Our Ref: TR040011

Planning Act 2008 – Section 51

Application by North Somerset District Council for an Order Granting Development Consent for the Portishead Branch Line – MetroWest Phase 1

Advice following issue of decision to accept the application for Examination

Drawing: EASTON-IN-GORDANO FLOOD MITIGATION PLAN

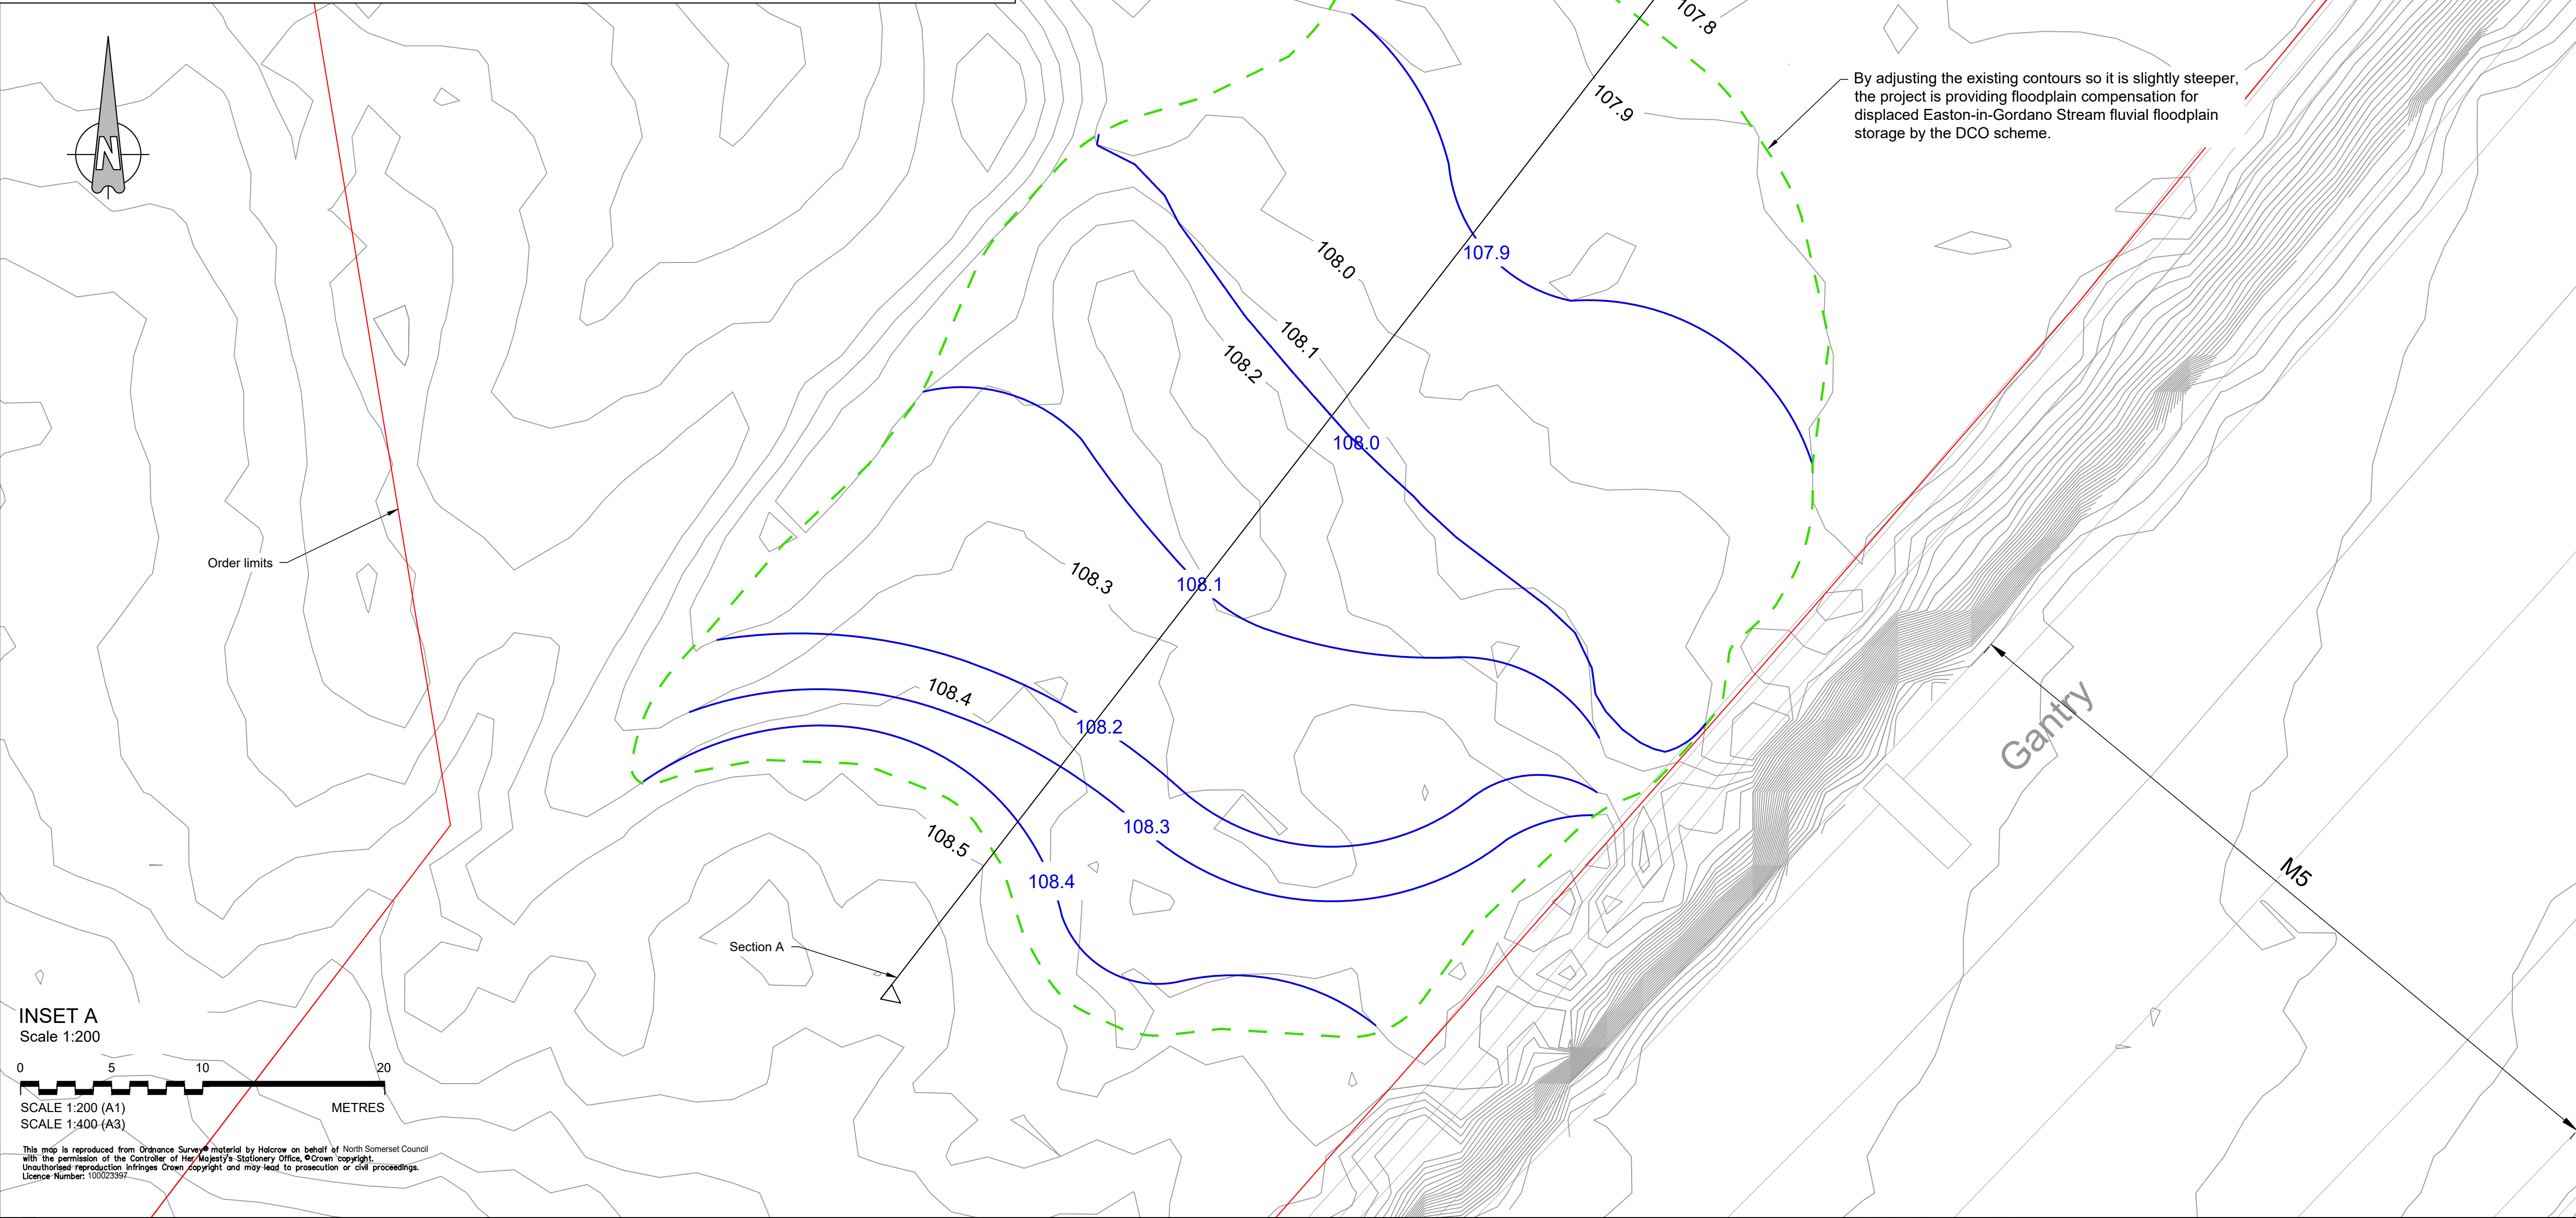
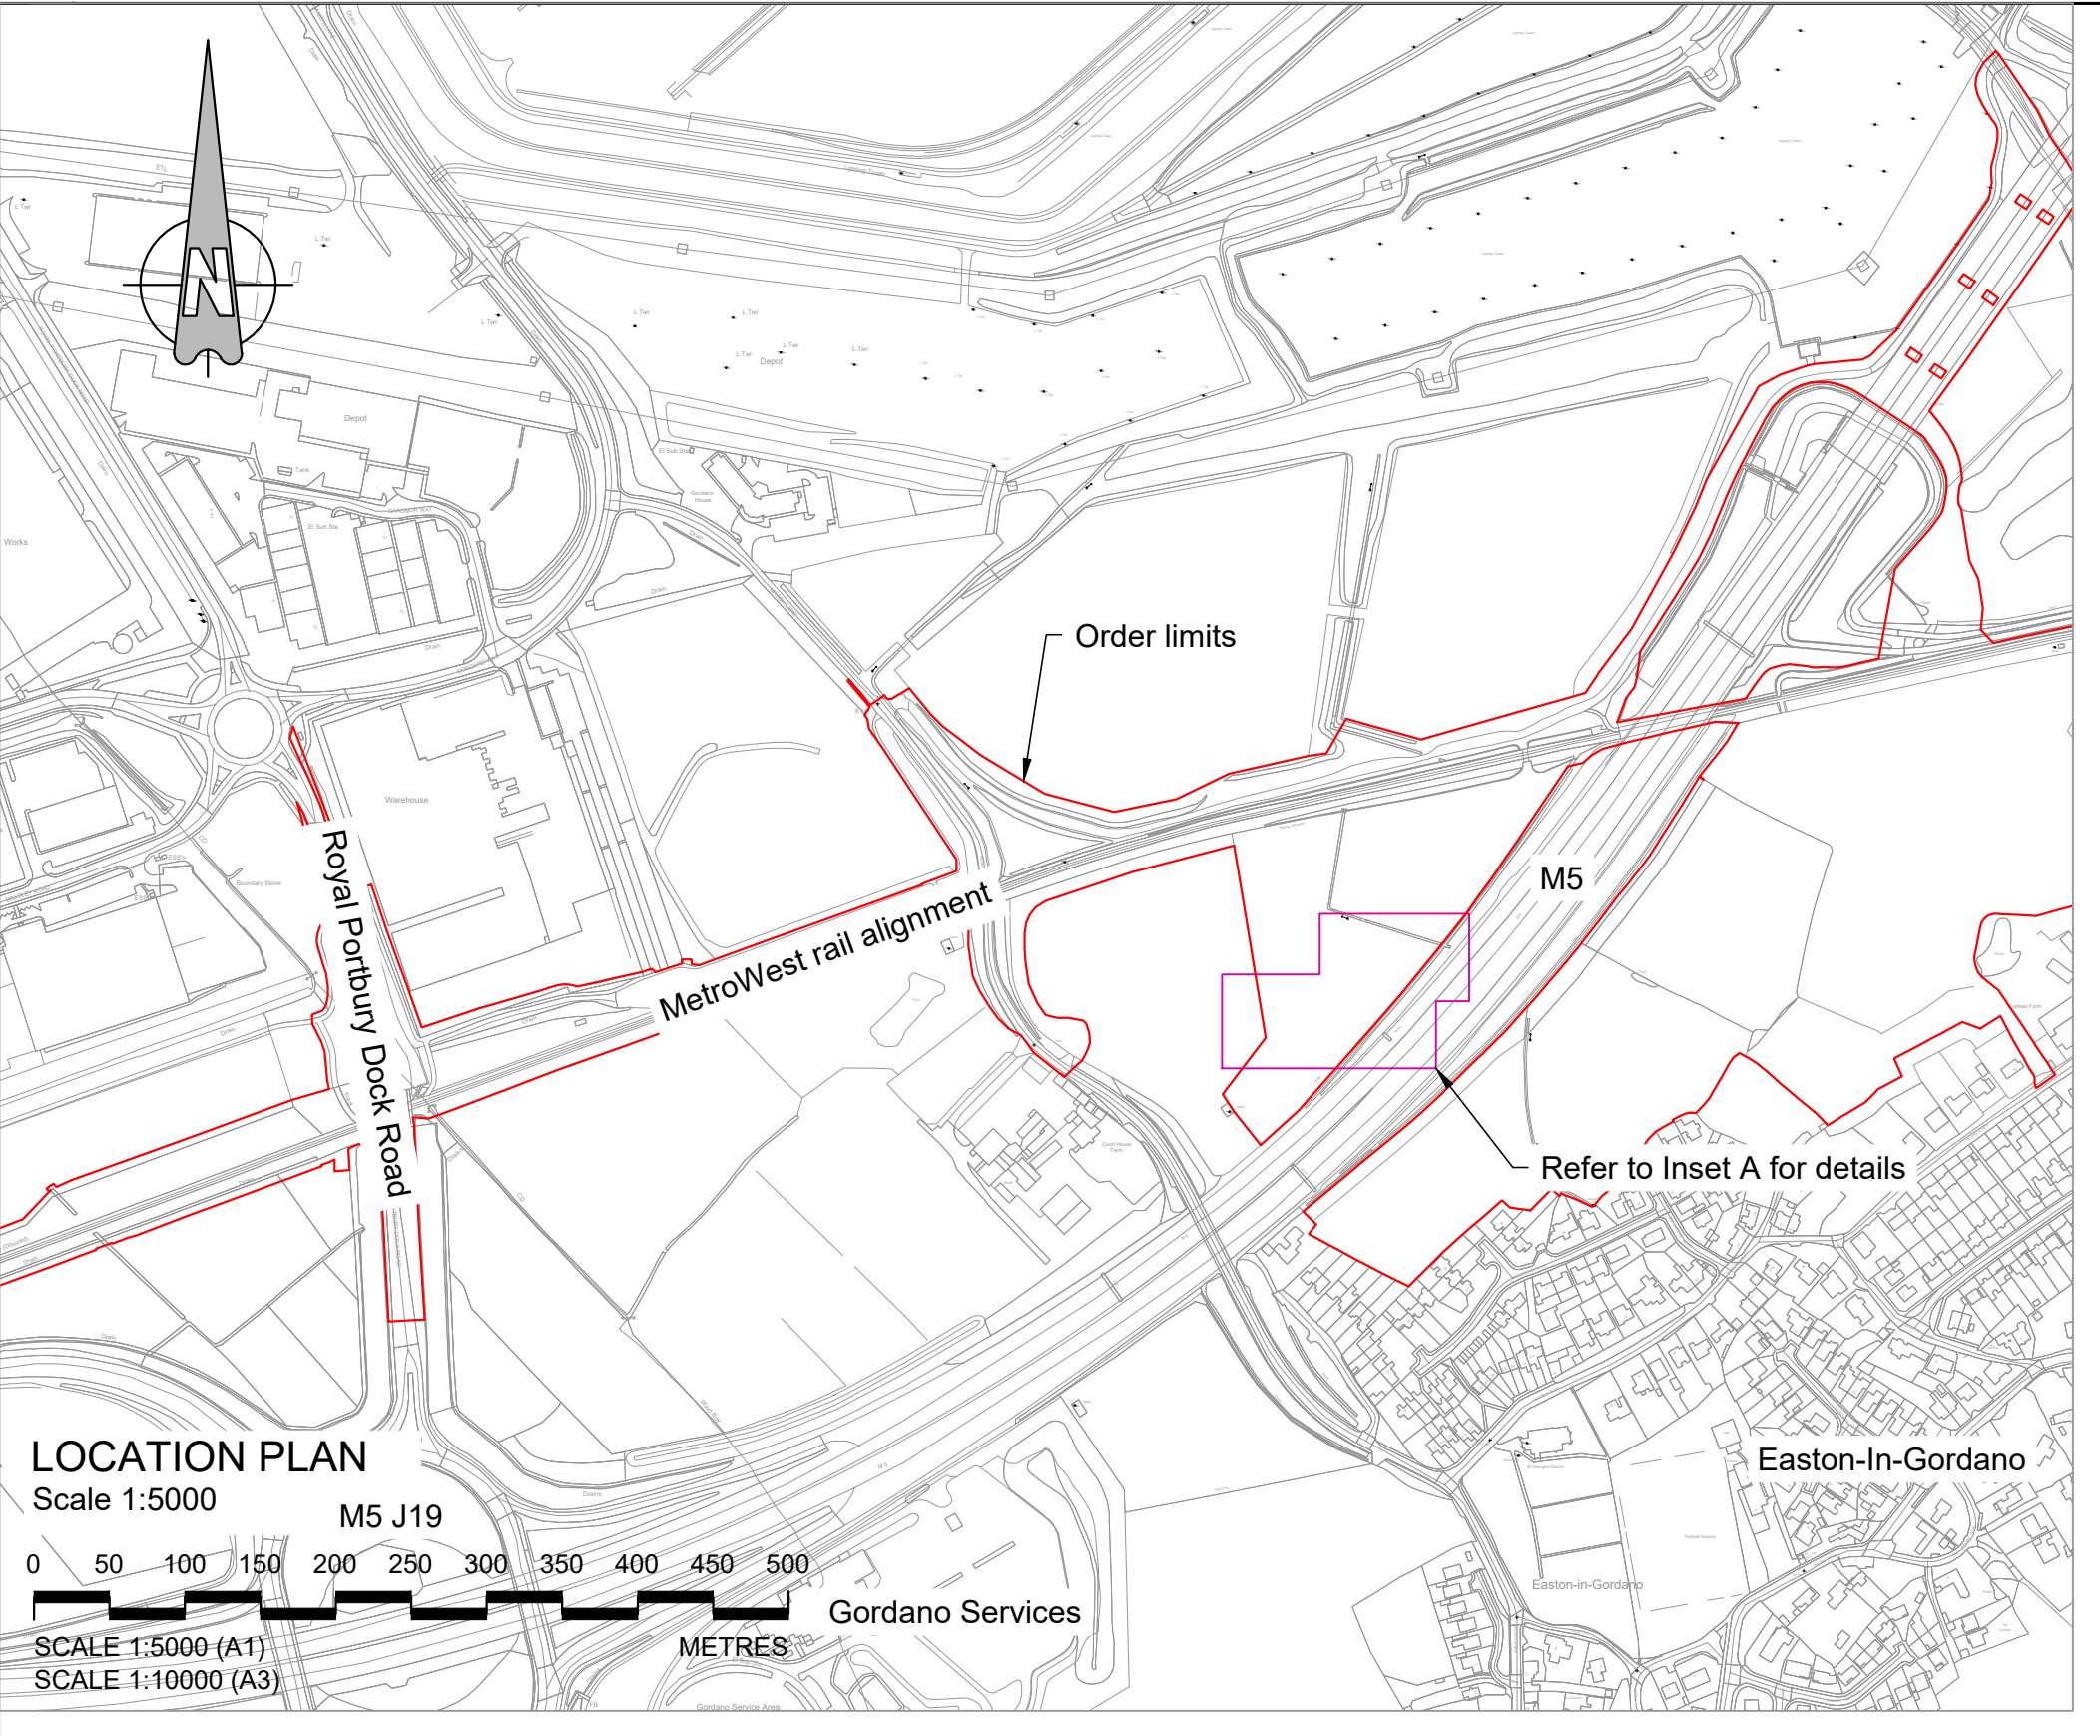
The Applicant also proposes to increase the footprint of the railway embankment within the Easton-in-Gordano Stream floodplain which would result in displacement of potential floodplain storage, south of the railway. The Applicant therefore proposes floodplain storage compensation. In preparation for the examination the Inspectorate seeks to understand the extent to which the application of the revised climate change allowances may (or may not) affect the findings in this regard. In particular whether such detail would result in a need for increased levels of flood compensation to address greater levels of floodplain storage being displaced.
